Australian Technology Park Redevelopment SSD 7317

Submission to NSW Planning and Environment
9 March 2016

City of Sydney

Figure 9 – Building 1 (foreground in white) and Building 2 (background in white)
 Source: FJMT + SISSONS Architects

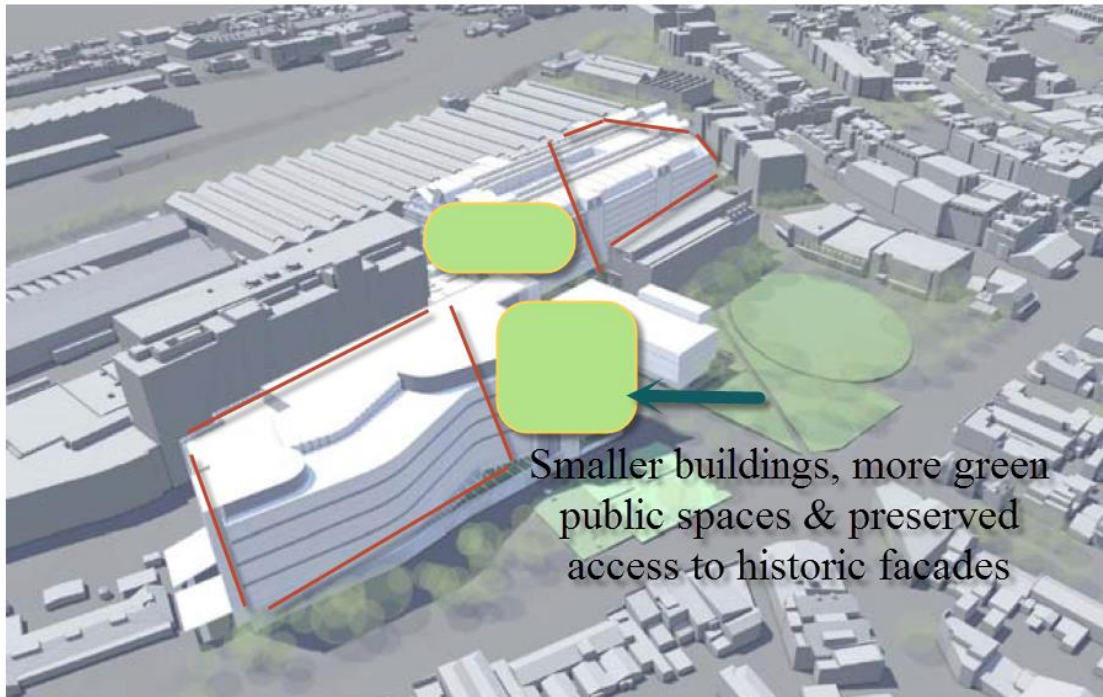
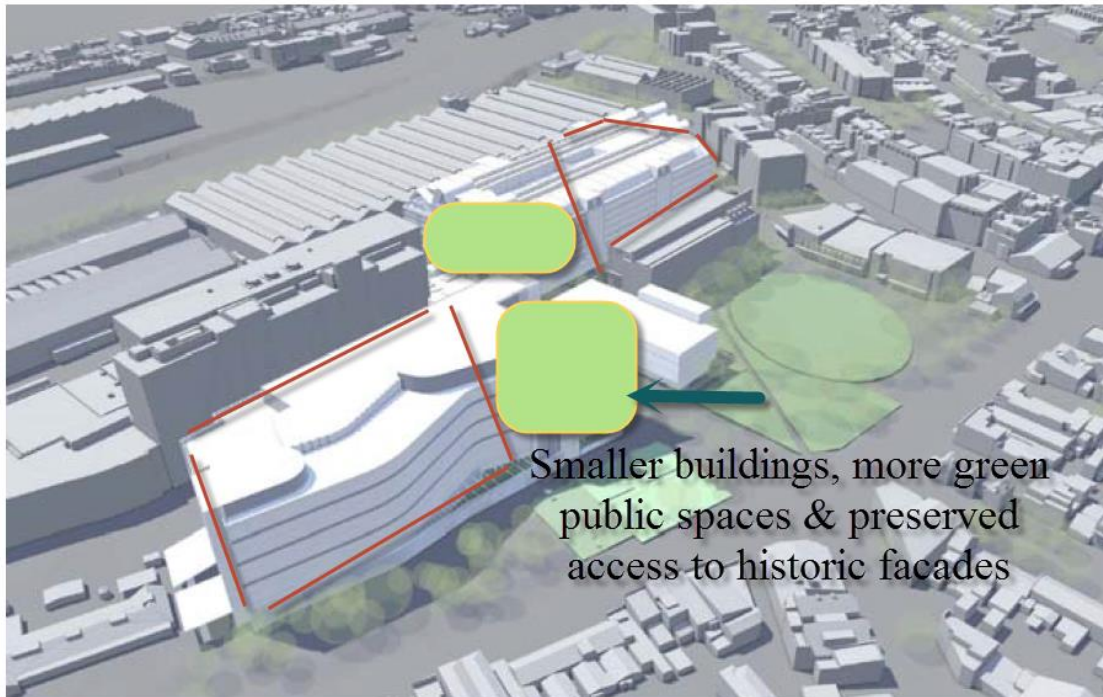
The addition of a second tall building, following the Media City construction, alongside the child care centre will have significant visual impact on the playground, overshadowing of the playground in the morning period and a contribution to a real sense of enclosure. The non-compliance, coupled with an at-grade car park immediately alongside the playground, eliminates any ability of the proposal to be screened by landscaping to soften its appearance.

The additional bulk and scale of the building at the western edge results in adverse additional overshadowing of properties along Henderson Road, many of which would not be overshadowed at all with a compliance scheme and many of which would get afternoon relief from overshadowing with a compliant scheme.

The existing 4-storey height control should be stayed and Building 1 height reduced from 9 storeys to 4 storeys by redistribution of GFA to create a more appropriate scale shift to development to the west and reduce overshadowing and visual impacts on surrounding properties to the west and south.

Figure 1 – Extract from MD SEPP maximum GFA map
 Source: NSW Legislation website and JBA

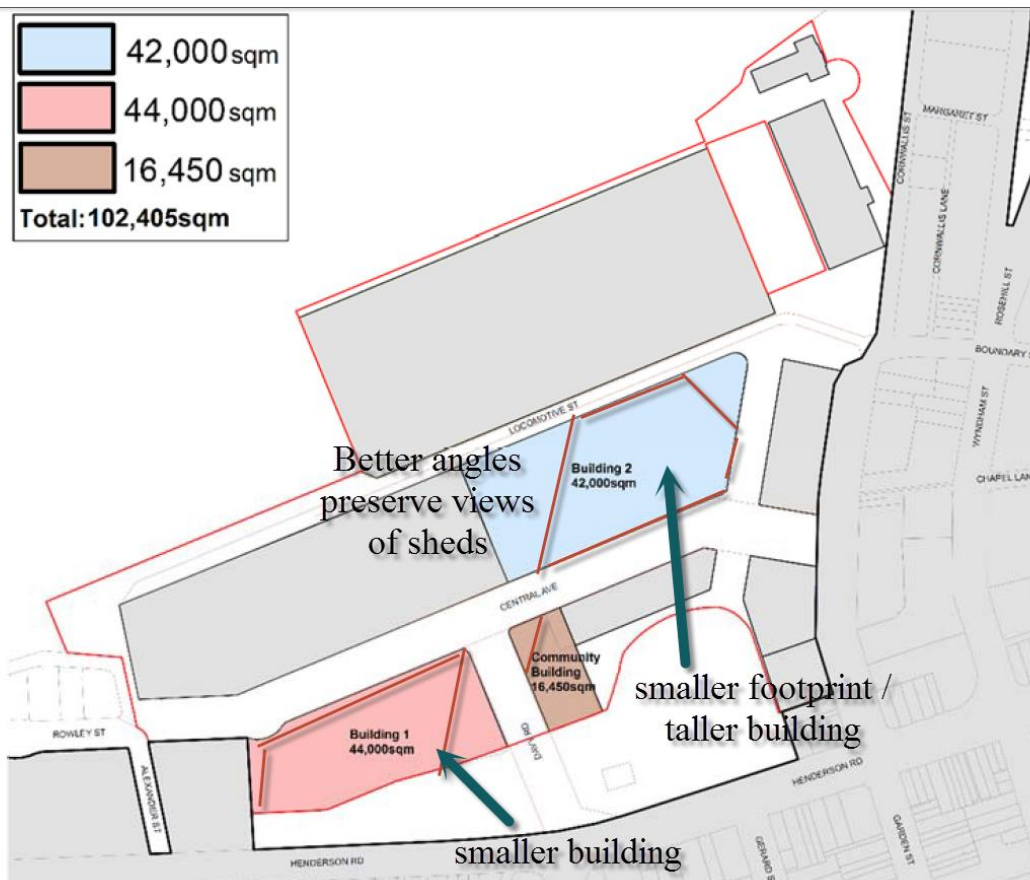
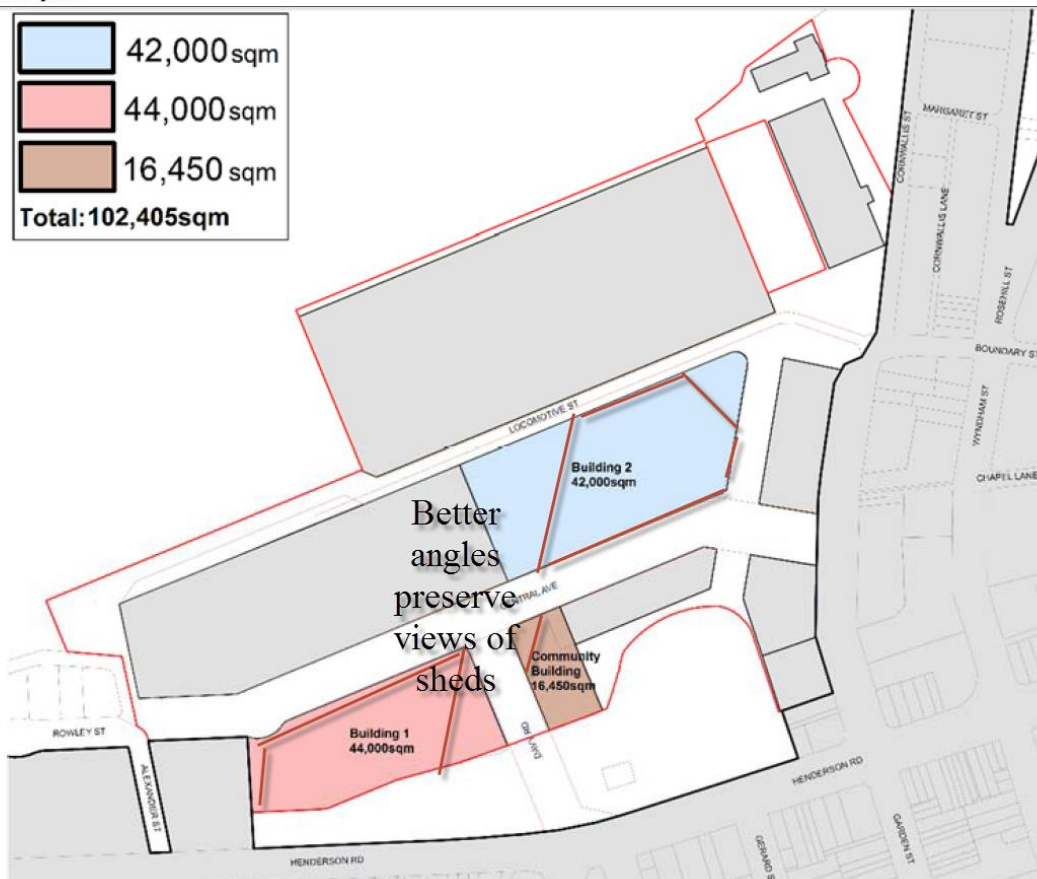
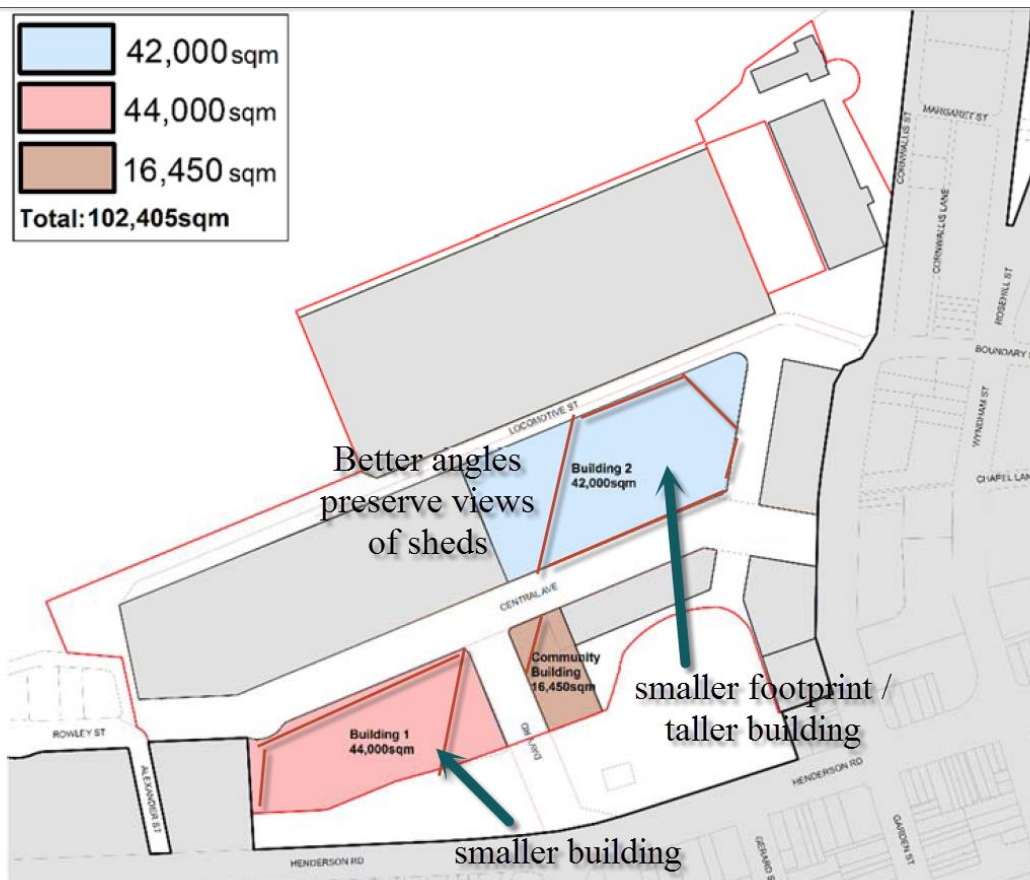
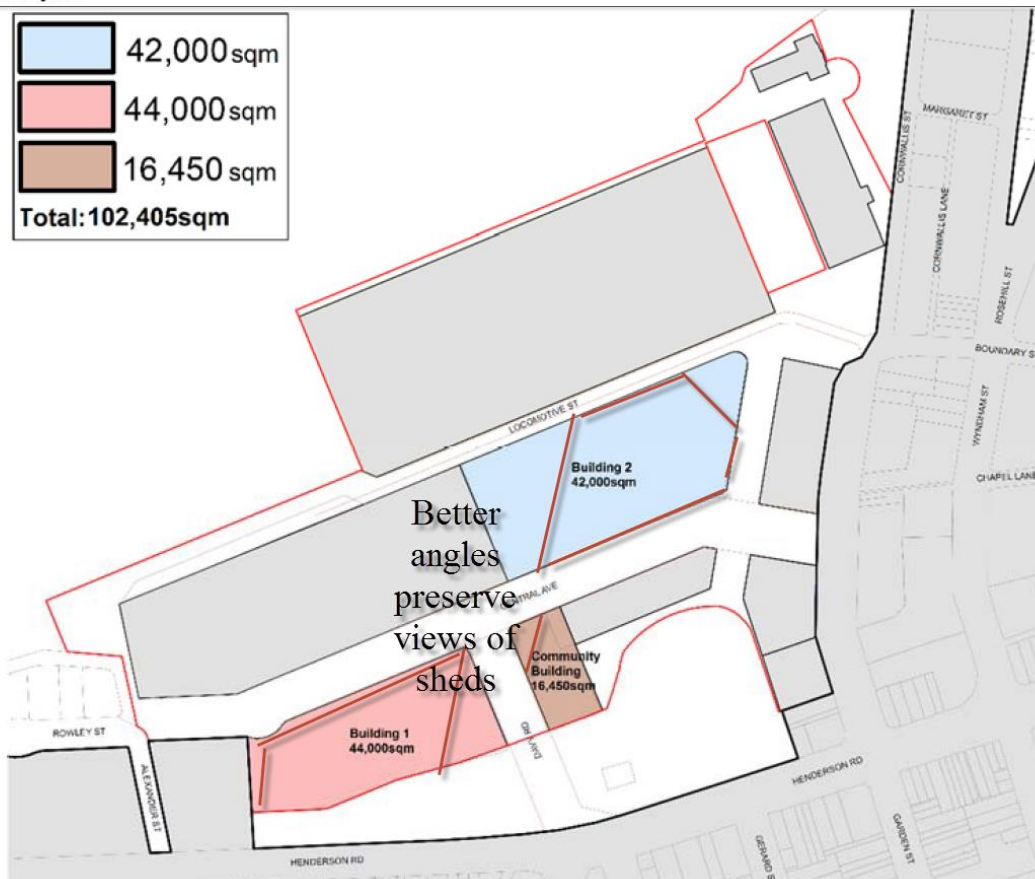
The proposed non-compliance with the building height standard in State Environmental Planning Policy (Major Development) 2005 is not well-founded and cannot be supported. The development is easily capable of achieving compliance with the legal planning controls and the commercial objectives sought through redistribution of heights and/or reallocation of GFA between buildings.

The height control requires the transitioning of building height from east to west. The Media City building reflects this scale shift.

Building 1 must comply with the building height standard in the Major Development SEPP.
